## **ADDITIONAL STATEMENT**

### **Response to Kirklees Planning**

#### **Beaconsfield Farm, Paul Lane, Flockton Moor Class Q application – Permitted Development**

south elevation

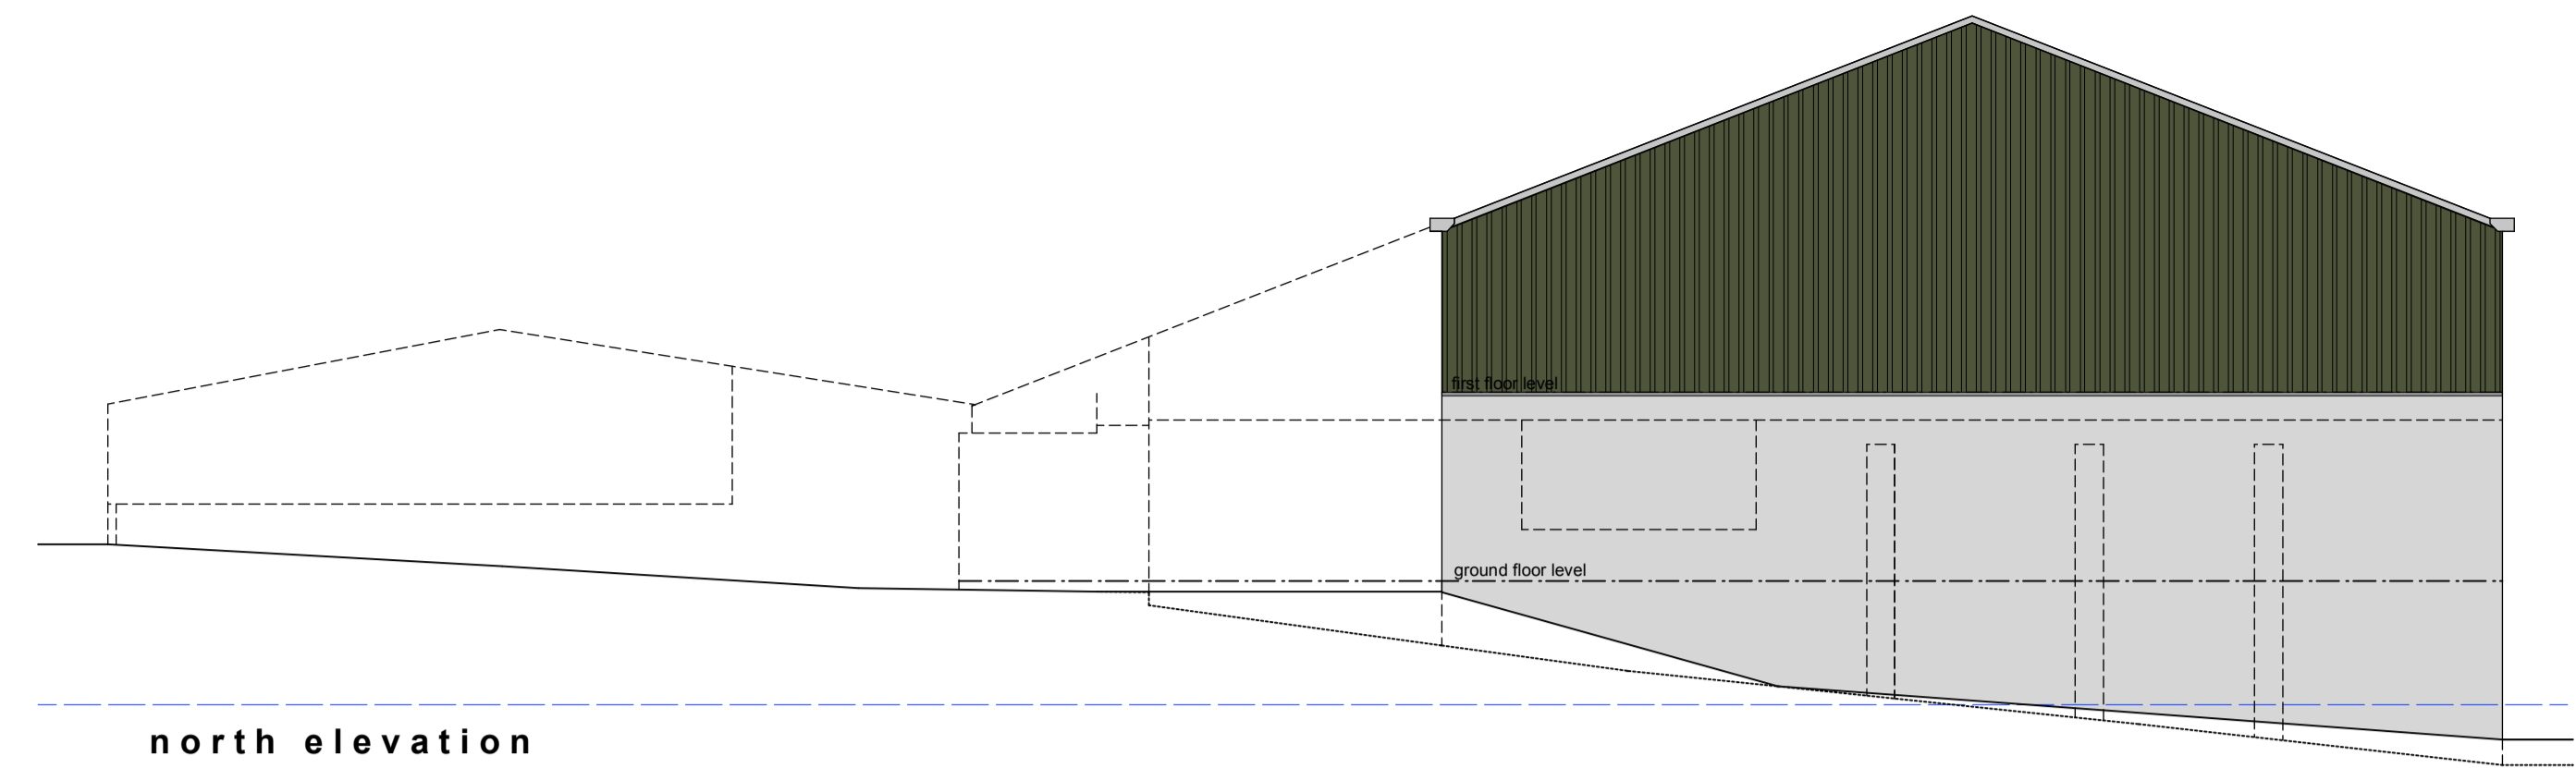
*The east elevations indicate the same removal and replacement of existing cladding whereas the structural report indicates that the internal concrete block wall is to be demolished meaning the entirety of the existing east elevation of the proposed building will be new material. It can also be reasonably assumed that new cladding would be placed on the north and south proposed elevation. The structural report also indicates there is no concrete wall base on the proposed south elevation meaning the entire south elevation is to be new material.*

There is no concrete base wall on the south elevation, this would have been removed when the extension was added (which is now to be removed). Hence the need to build this wall to enclose this end of the building. See image above.

west elevation

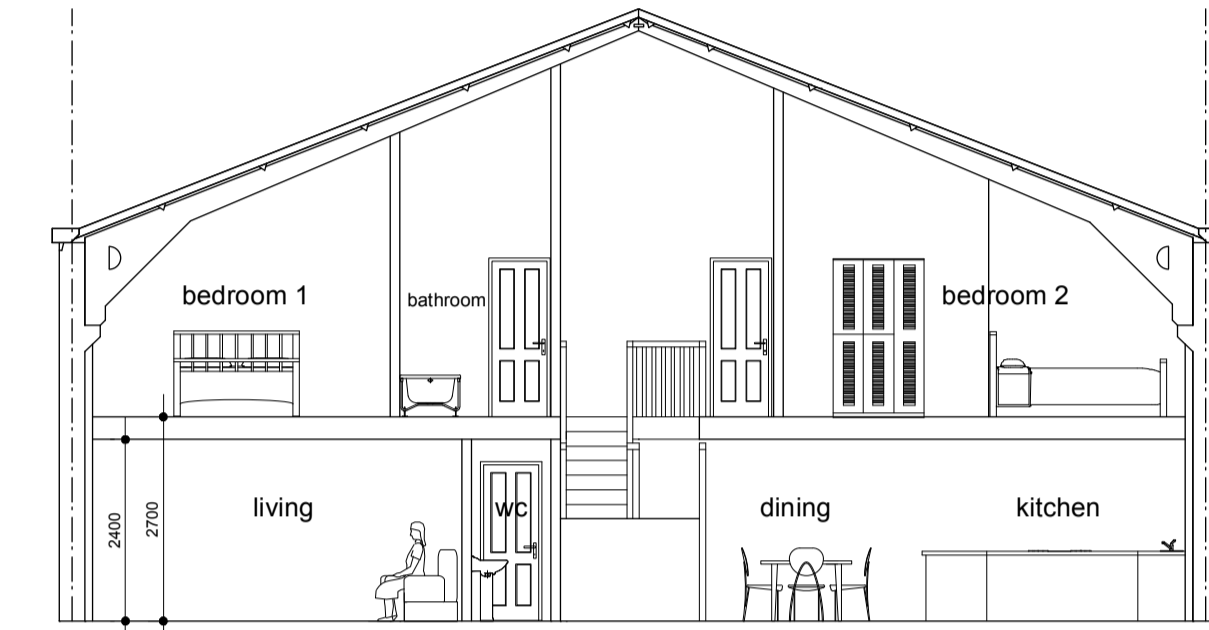
*The submitted elevations indicate that the existing roofing and cladding above the concrete wall on the west elevation is to be removed **with only the concrete wall base**.*

with only the concrete wall base? Should this say "concrete wall base retained"? Please clarify.

Yes, the wall and roof cladding is to be removed and replaced with products that will give compliance with the Building Regulations, for the proposed dwellings that are to be created. This is a mandatory requirement of any type of "barn conversion" to dwelling, irrespective of how the original barn has been constructed.

Surely it is not to be expected that we retain the existing corrugated asbestos roof and wall claddings, with no thermal insulation, not to mention the asbestos issue?
